Subject: Application 3/2023/0165 FAO Kathryn Hughes

Planning Application Reference No.: 3/2023/0165

Address of Development: Land at Neddy Lane Billington BB7 9LL

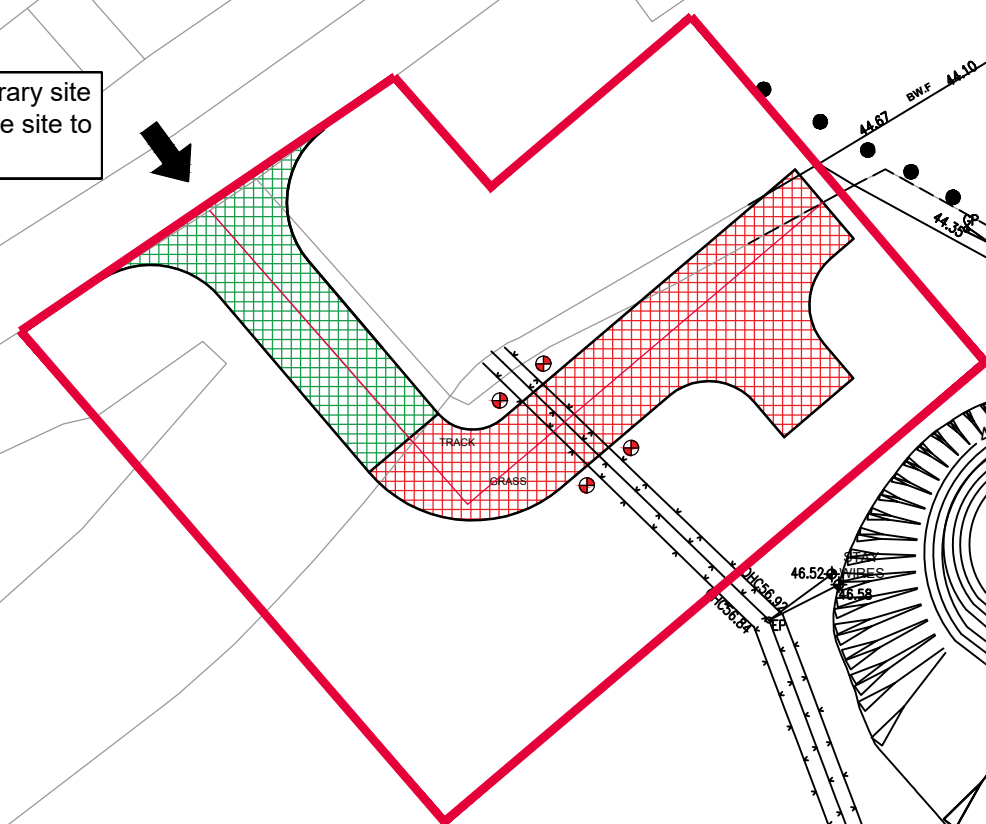
3) If Ribble Valley should be minded to grant this application, is the Authority completely satisfied that temporary permission needs to be for 12 months and not for a much shorter period, such as 3 months? The attenuation pond being excavated shows on the plans as being oval with a cross-section of 20m. x 5m. without any depth quoted – such a small pond should not take a year to excavate surely ??

Moreover, the planning application does not provide any information regarding the number and type of vehicles that the builder wishes to ingress and egress from the site. We believe that such information is pertinent to the application since it will have an impact on the disruption to the residents.

We also question the need for a 12 months temporary permission when it seems that the work required could be done in far less time. The lack of information in the application about the amount of silt that will be created and the protection of the habitat from it is another concern for us. We are worried that silt will run off into the ditches and streams adjoining and into the River Calder, which is a threat to the habitat and ecology of the Calder. The Calder is a noted brown trout fishery, and it is home to sea trout and salmon, the latter being a protected species in rapid decline. We can see nothing in this application that addresses this problem.

I believe that the removal of soil and debris from the size of pond quoted could be done within a calendar month and would cause only a minimal temporary upset if an alternative route is used.

Proposed location for temporary site access. Vehicle access to the site to be: left in; left out.

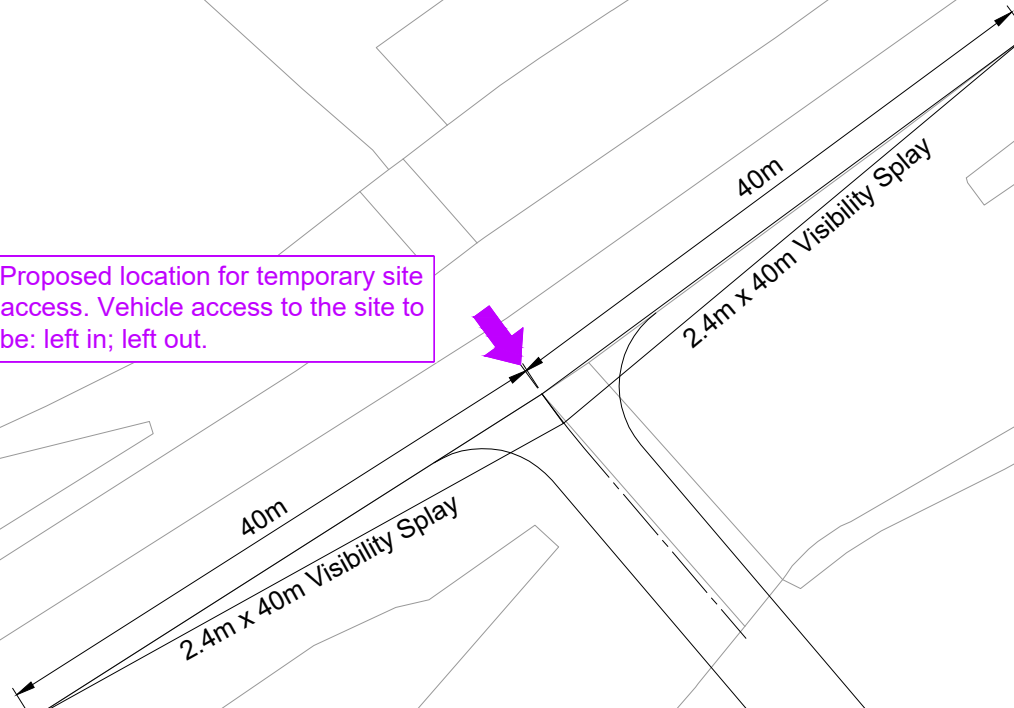
1) Permission should not be granted giving 'temporary' access to the A59. The point of access will cause a particular traffic hazard. Vehicles travelling at 60 mph as they come off the bend after the roundabout, will encounter heavily laden trucks moving off slowly, leaving unsafe road surfaces. Debris from the trucks, which could also include stones/bricks wedged between the rear double tyres, is likely to result in cracked windscreens and worse.

Firstly, we share the view that creating a 30 mph length is not guaranteed to be safe, and in fact, may cause undue congestion on this main arterial road with a high volume of traffic. We have experienced traffic congestion caused by builders in the Ribble Valley, and we are concerned about the potential hazards that may arise from dirt and mud accumulating on the road from heavy vehicles accessing the site, especially when wet.

I am a regular user of this section of the road and it is one of the few where the flow of traffic is unobstructed and reliably fast flowing. I believe that a new access point onto this section, be it permanent or temporary, will be a significant danger to all road users.

A reduction of the speed limit to 30mph will cause congestion and will be a collision danger to users unfamiliar with the change in limit.
